29 March 2026

**Re: Development Proposal for 40-48 Redan Street, Mosman
SSD-93020230**

40-48 Redan Street, Mosman 40-48 Redan Street Mosman NSW 2088	Elevation West - Redan Lane Elevations	Rev Date Description By Chk	Scale	Code	Sheet	Rev	0 2.5 5 10m
		B 27/2/2026 SSD Submission Lodgment IS	1:250 @ A3	TPRS	3003	B

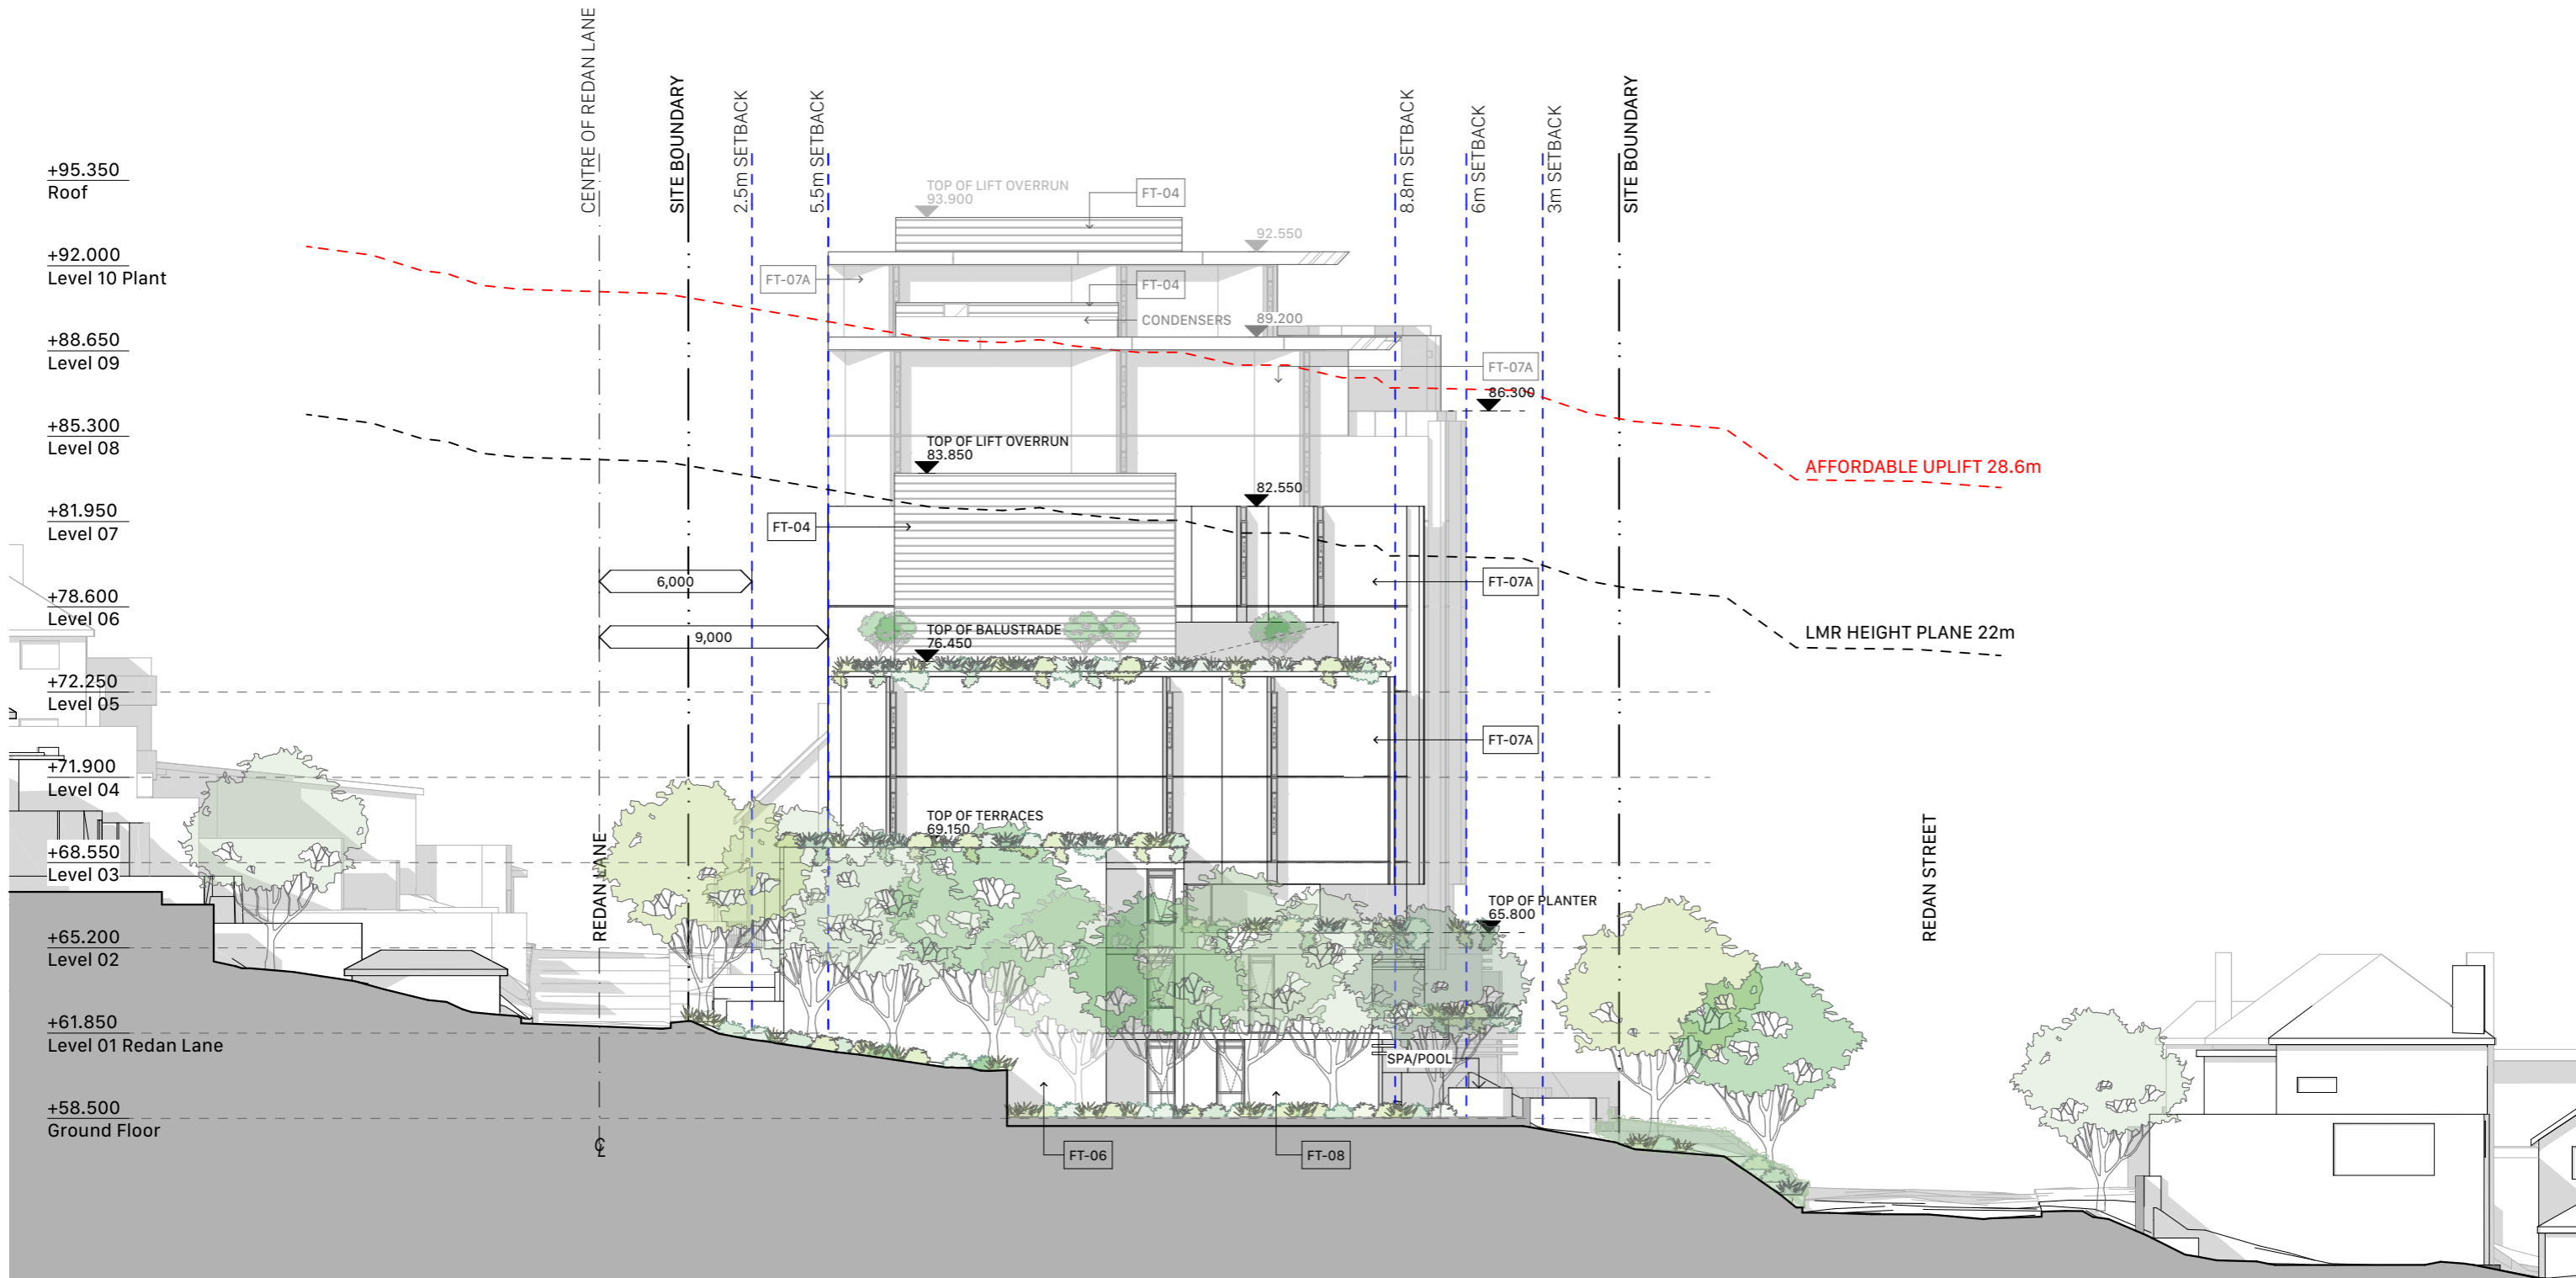
The architectural drawings indicate that the proposed building includes habitable room windows and balconies facing west over Redan Lane directly towards our home. In the other direction, we will have sightlines towards the residents' bedrooms and bedroom balconies. This is a design failure and should not be permitted.
